MIDTOWN COLLECTION AT HANNAH RIDGE FILING NO. 1

CHUCK BROERMAN, RECORDER
BY: _____ DEPUTY
MIDTOWN COLLECTION AT HANNAH RIDGE FILING NO. 1
JOB NO. 1116.30
JANUARY 15, 2019
SHEET 1 OF 3

Markup Summary 9-9-2019

SF-19-007

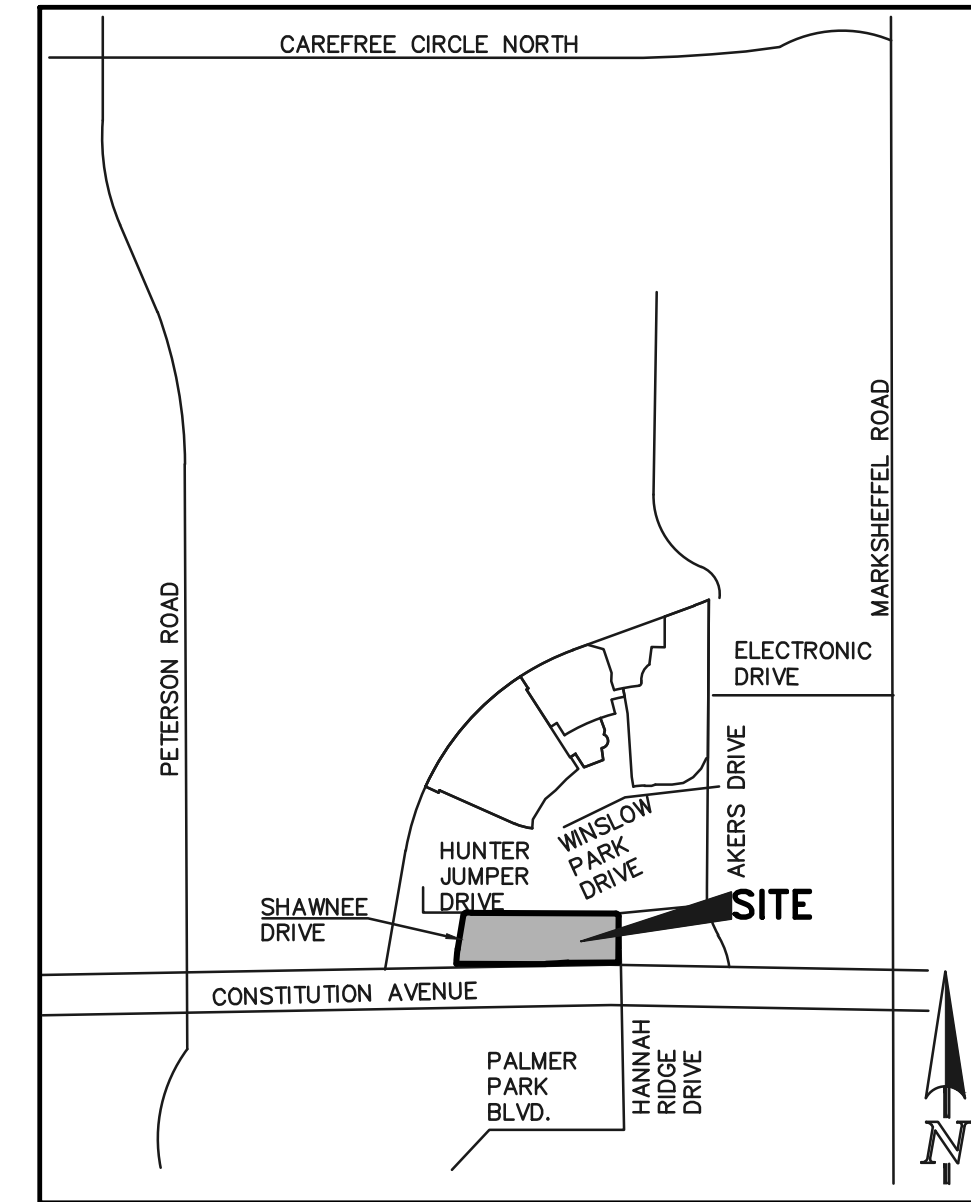
LOI states that one filing is on a District and the other in the other District. Cimarron Hills has commented that the plat is not within their District

Please follow up with Lori and submit PID inclusion

Noise wall should be identified by note and installation and maintenance of that noise wall

PRESIDENT, BOARD OF COUNTY COMMISSIONERS
Delete BoCC if you would like admin approved plats DATE _____
